Andrew Beattie - Submission Details for David Gray (comments)

Content:
 Parramatta City Council Officer Submission

Proposed Homebush Bay public transport and pedestrian/cycleway bridge (Wentworth Point to Rhodes)

Submission for Job: #4331 Homebush Bay Bridge - Project Application

SECTION 2

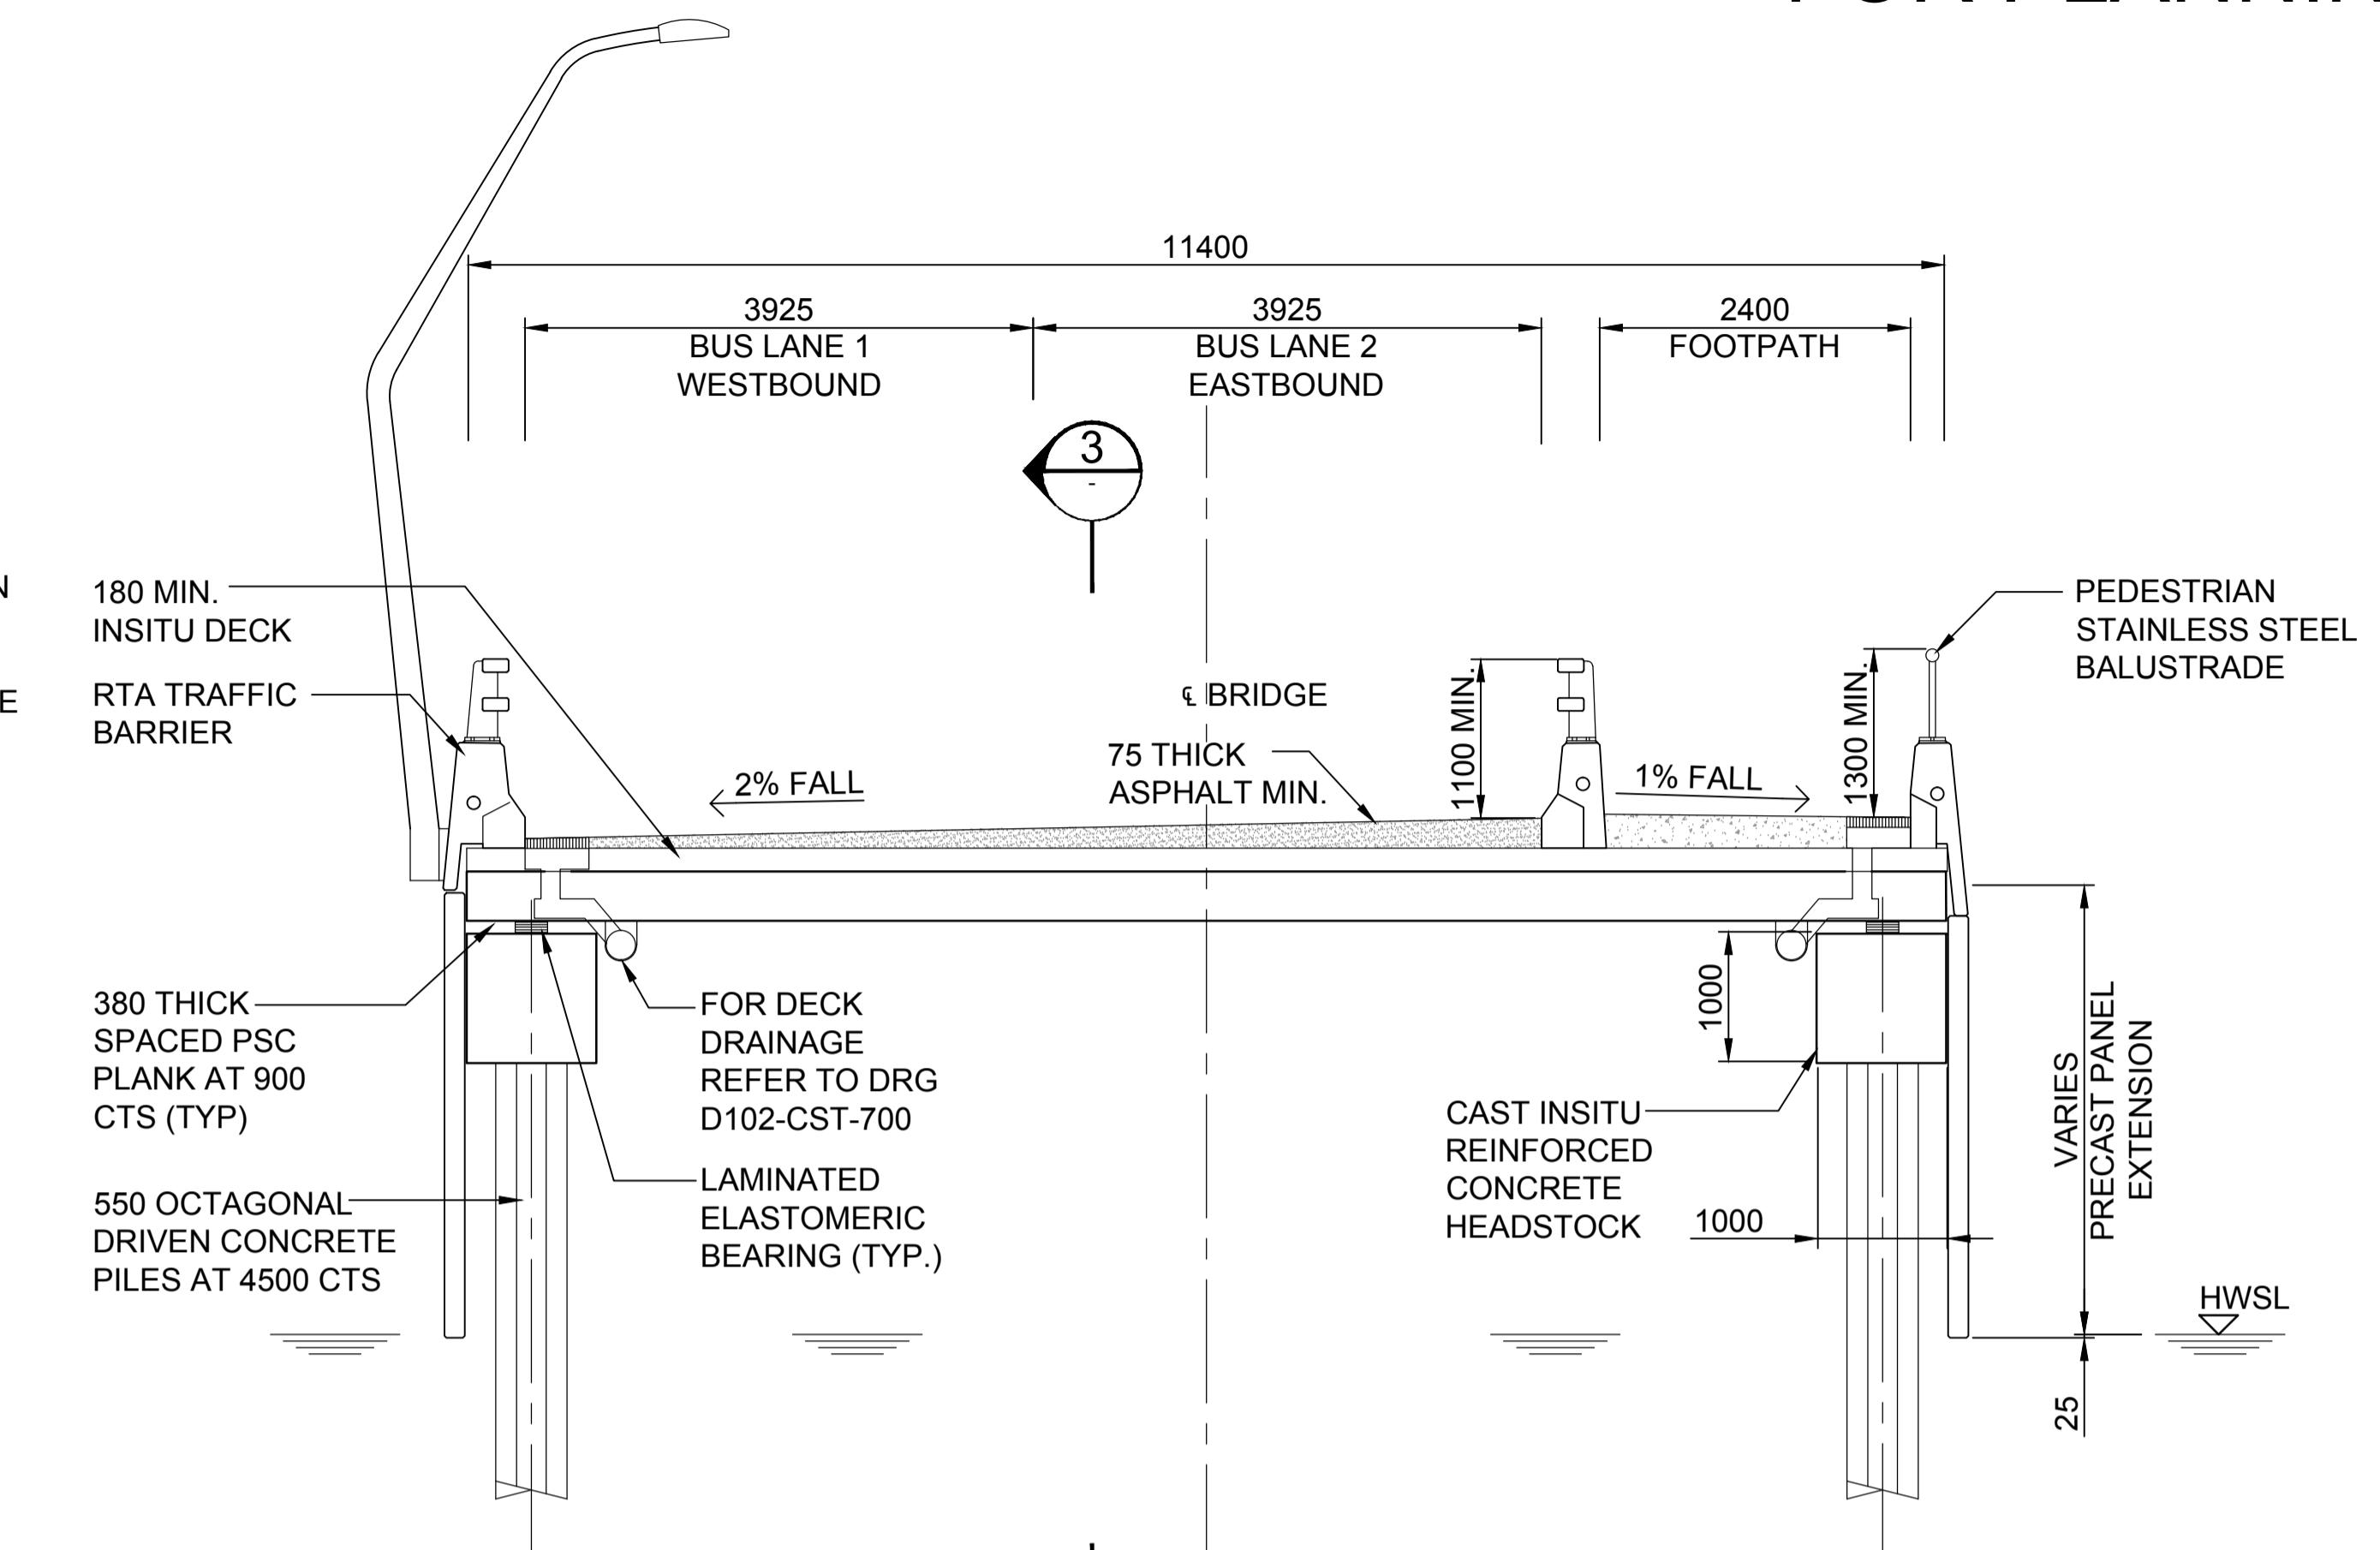
The proposed width of the pedestrian space is 2.4m (on the approach) which is questioned as width of double pram or mobility scooter is approximately 750mm plus reasonable operating clearance leaving little passing space for such a long span bridge. We would suggest a minimum of 3m along the whole of the bridge including the approach.

The proposed arrangement for cyclists is to share the bus lane which has a width of 3.95m on the approach and 3.65m on the bridge with balustrades on both sides.

The RTA Guidelines recommend shared bus-cycle lanes of 3.0 to 4.5m (Figure 5.5) for which the proposal meets. However the proposal does not consider the need for additional width due to the continuous balustrade. The RTA guidelines recommends clearance of 0.5m to 1.0m to walls and fences (Table 6.2). This is for off-road cycle routes but we believe it is applicable to this on-road situation as there is a continuous balustrade across the bridge. In addition this clearance becomes more important when factoring the effect of cross-winds across Homebush Bay upon cyclists crossing the bridge.

Figure 3.7 – Lane configuration options

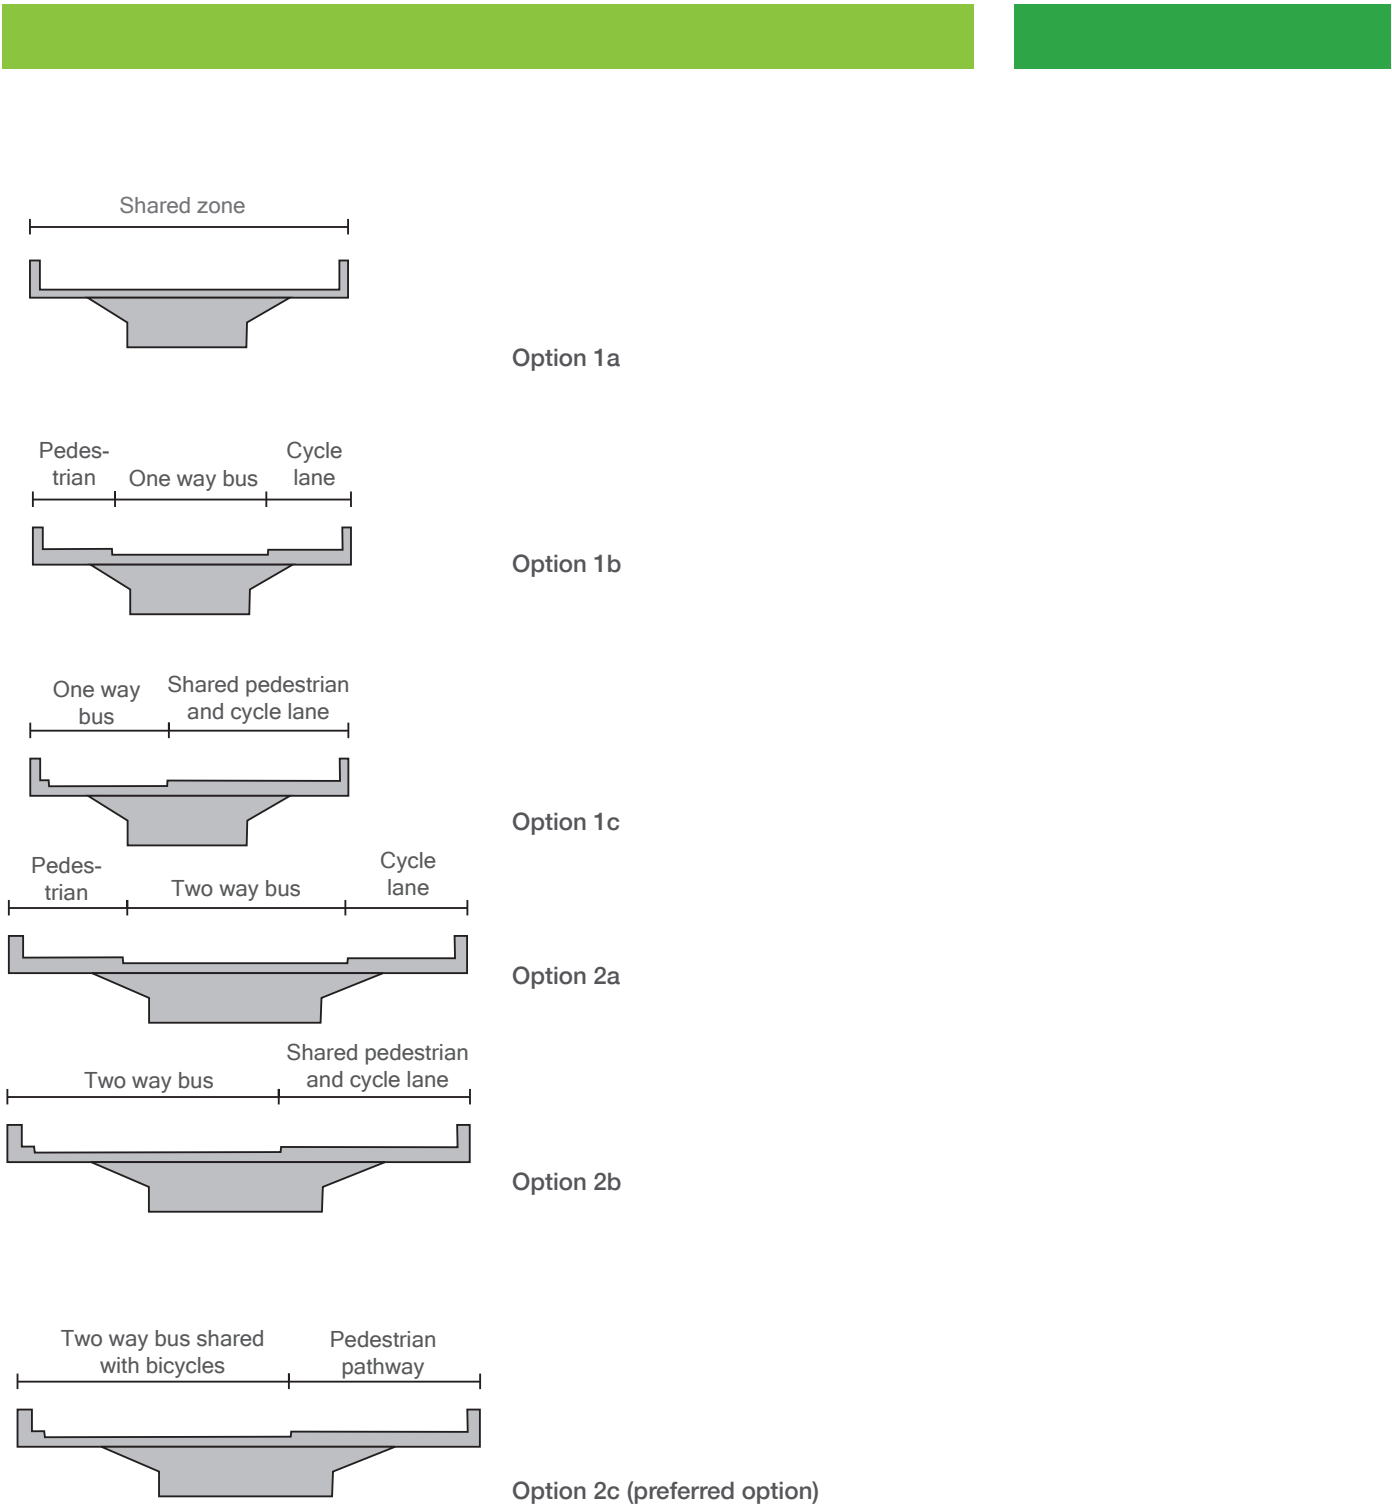
Officers recommend that the optimal bridge lane configuration option is 2a which is segregated pedestrians, cyclists and public transport. We suggest 3m wide for the pedestrian facility and a minimum of 3.5m for the cycle facility as per RTA Guidelines.

Officers recommend that the optimal bridge lane configuration option is 2a which is segregated pedestrians, cyclists and public transport. We suggest 3m wide for the pedestrian facility and a minimum of 3.5m for the cycle facility as per RTA Guidelines.
